Requesting Administrative review and approval of minor revisions to the DRB Plan which was approved prior to final design of the approved development. Changes are consistent with original design intent.

RE: Minor Amendment to Site Plan – DRB, U Haul of West Side, PROJECT Number: PR-2018-001670

RE: Minor Amendment to Site Plan – DRB, U Haul of West Side, PROJECT Number: PR-2018-001670
Application Number: SI-2019-00181

1930 Albuquerque U-Haul BP-2020-44029

4 EAST ELEVATION

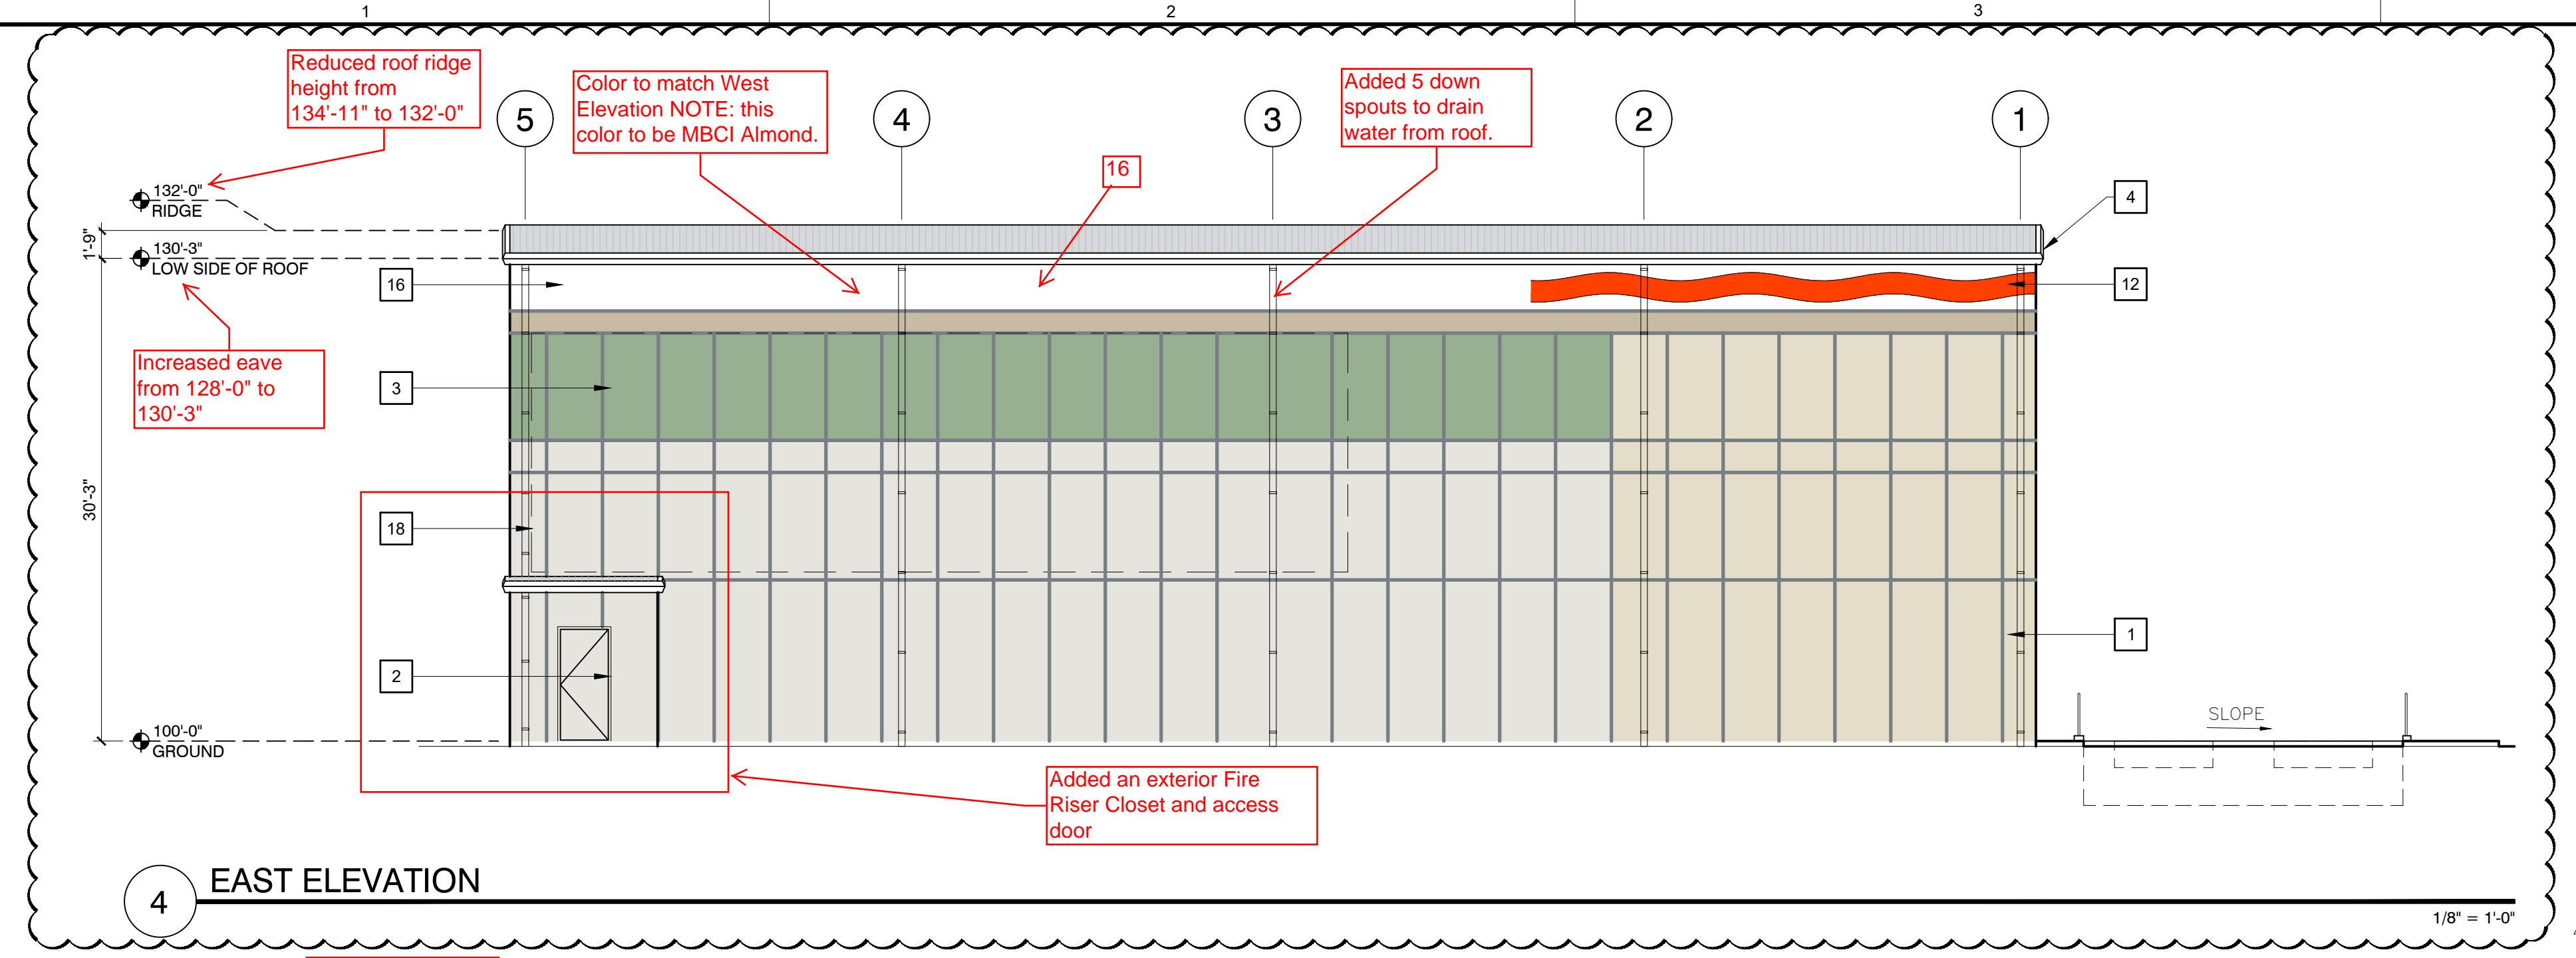
| Ev-1 | EAST ELEVATION: | AA202 |
| | <ol style="list-style-type: none"> 1. The Canopy was changed from a flat-roofed canopy to a sloped-roof to efficiently drain both the Canopy and the Main roof. | |

3 WEST ELEVATION

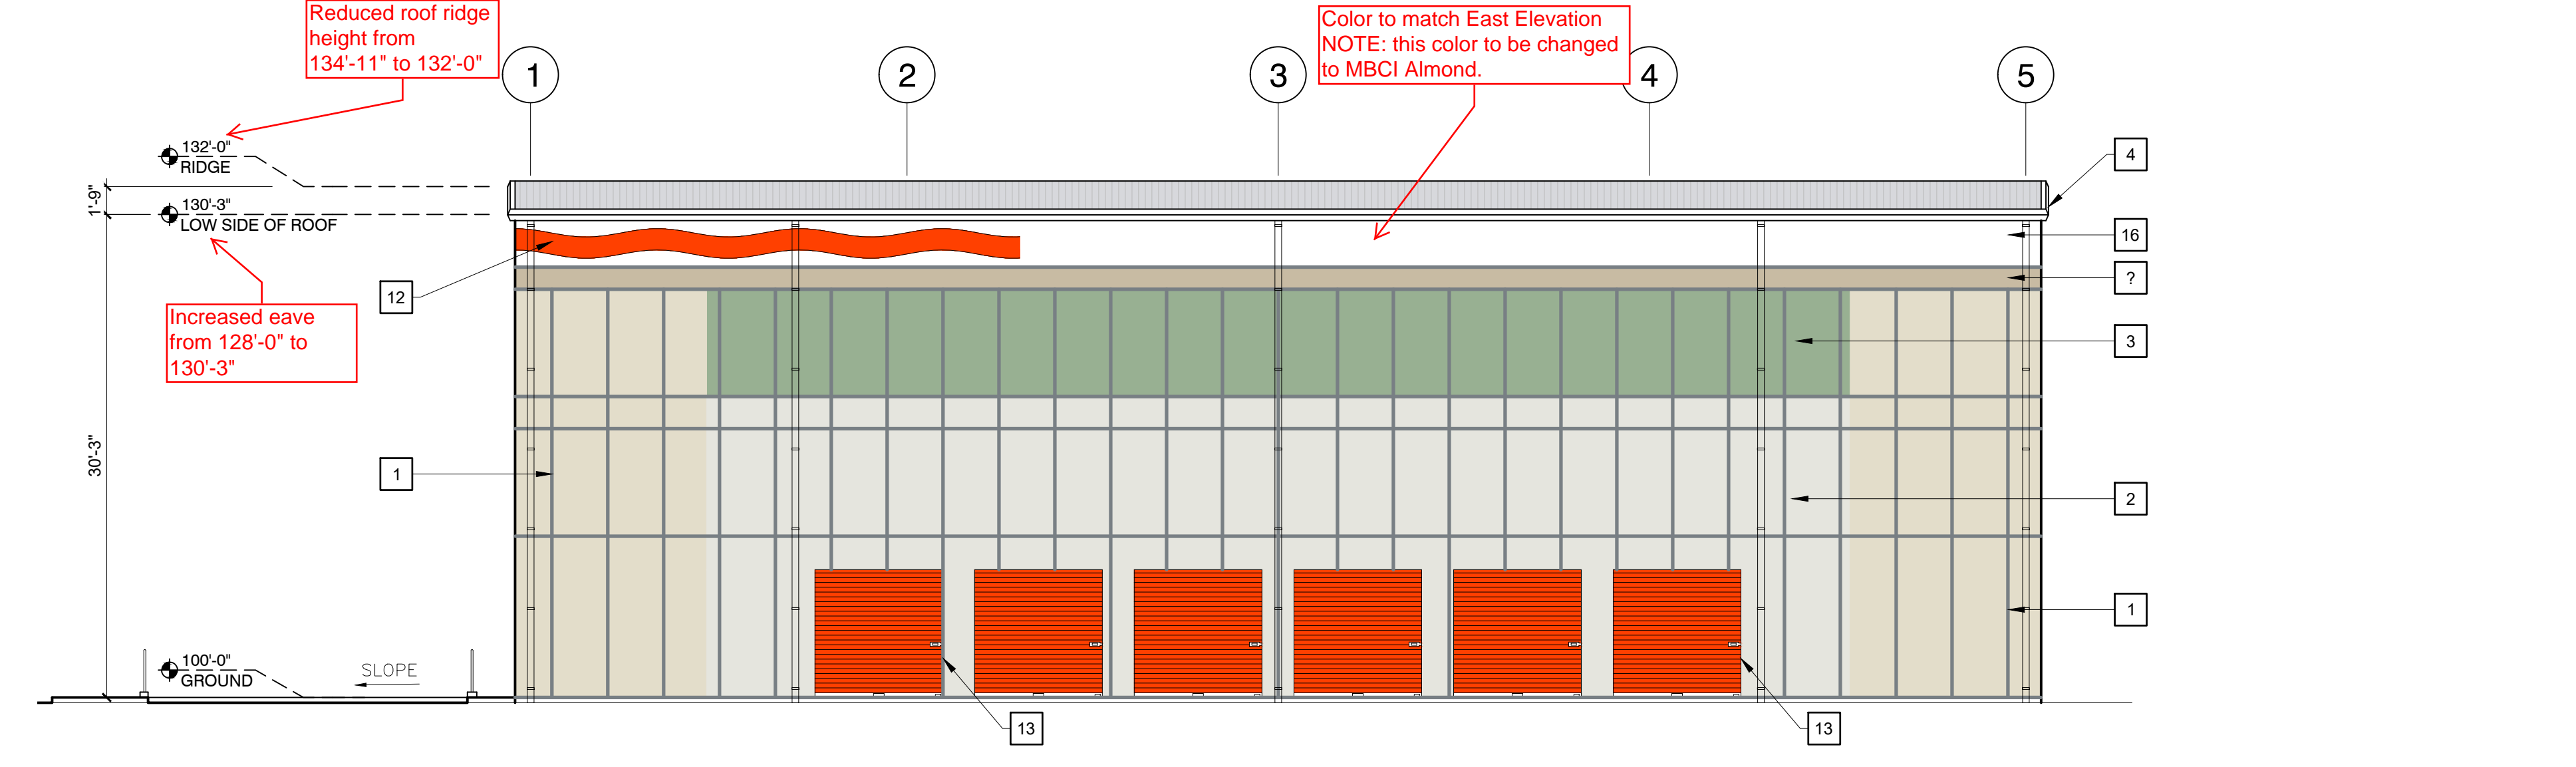
| Ev-1 | WEST ELEVATION: | AA201 |
| | <ol style="list-style-type: none"> 1. The Canopy was changed from a flat-roofed canopy to a sloped-roof to efficiently drain both the Canopy and the Main roof. 2. staircase was relocated to the South side avoiding conflicts with the Fire and an easement. | |

1 SOUTH ELEVATION

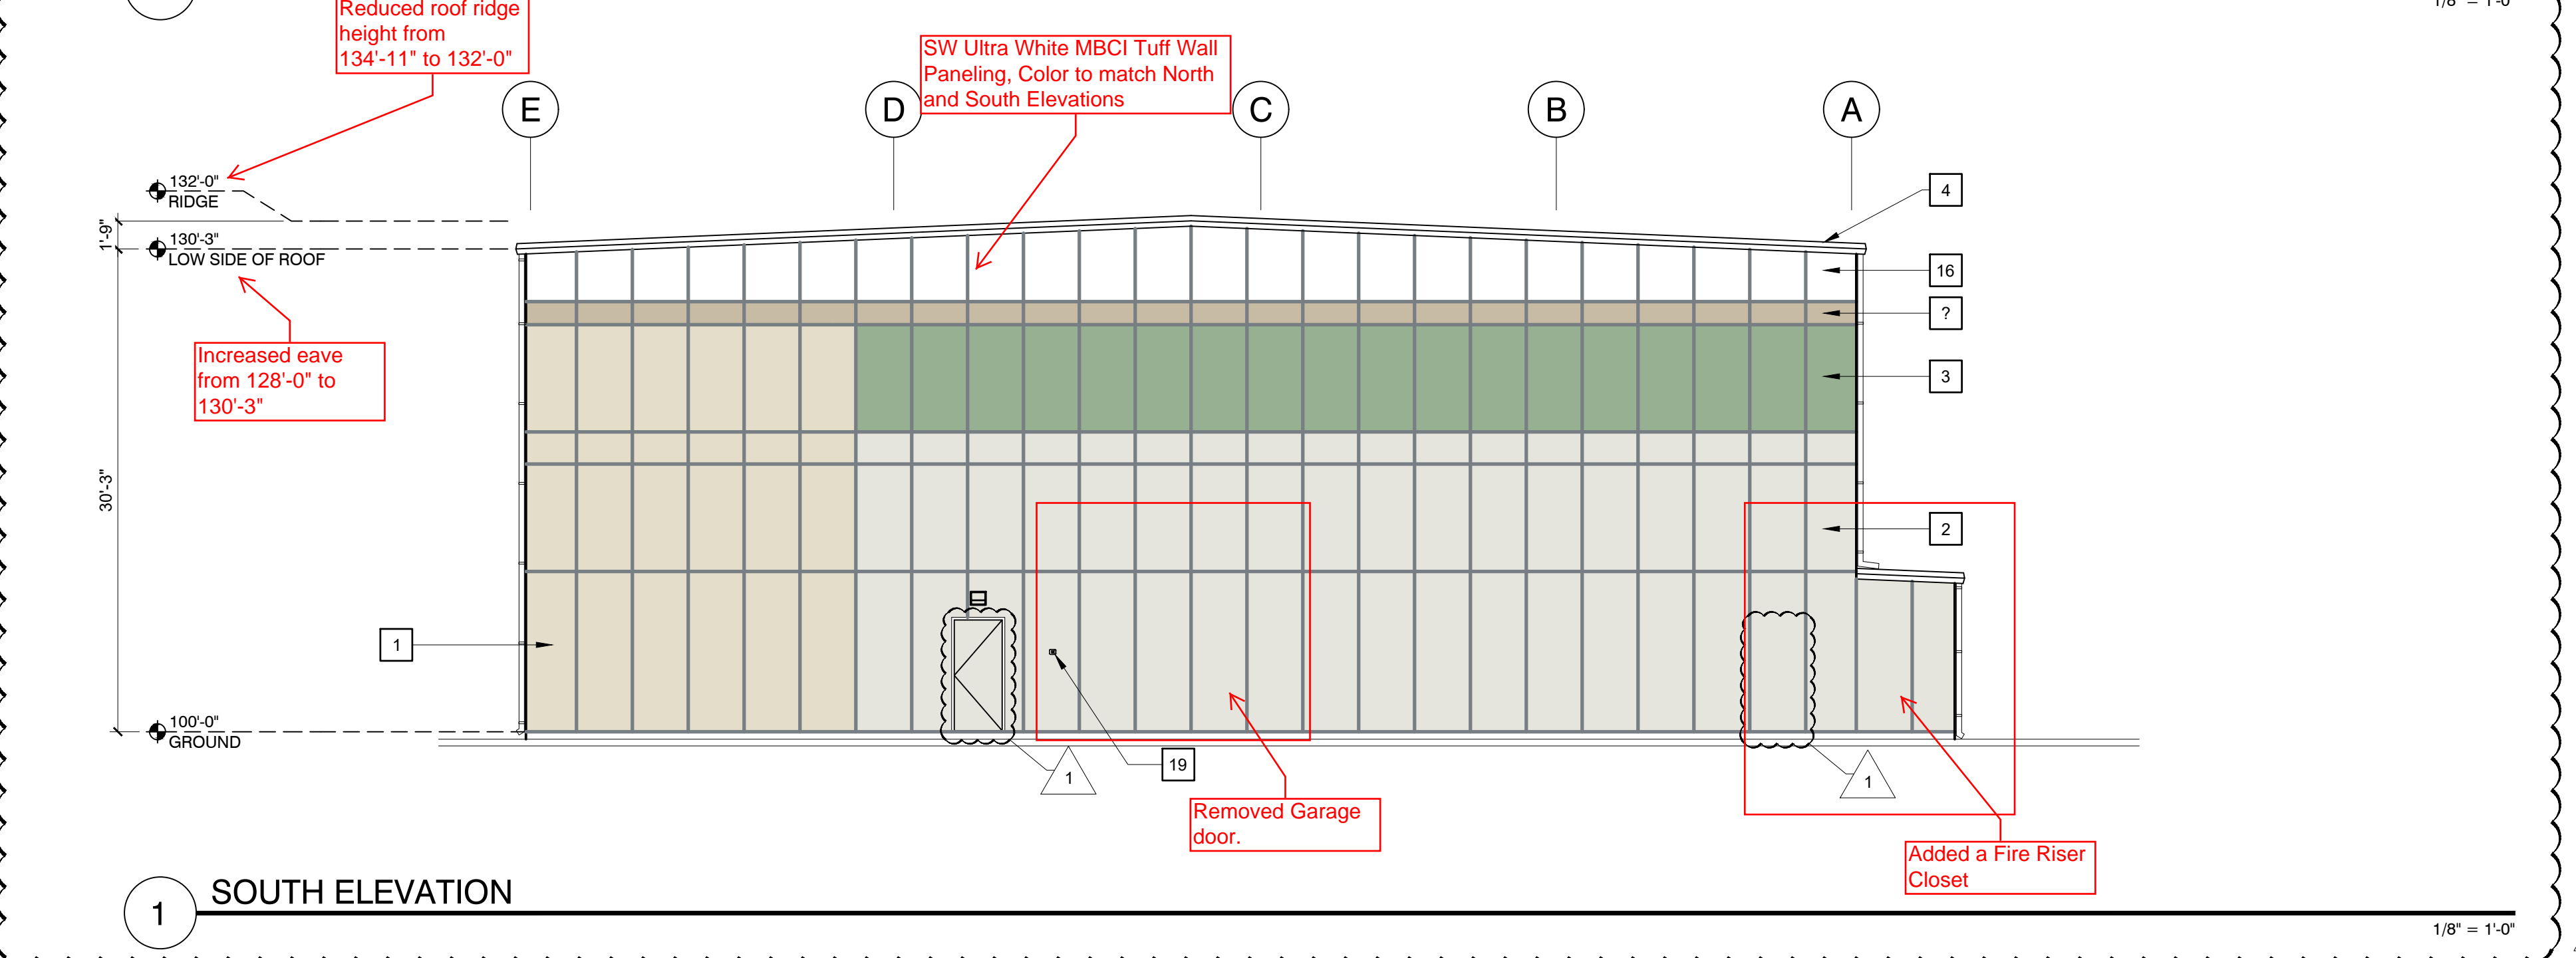
| Ev1 | SOUTH ELEVATION: | AA201 |
| | <ol style="list-style-type: none"> 1. Added more Down spouts to drain the roof water. The initial design did not have adequate number of drains for the size of roof. Down pouts Were adjusted to evenly drain roof water. 2. staircase was relocated to the South side avoiding conflicts with the Fire and an easement. | |
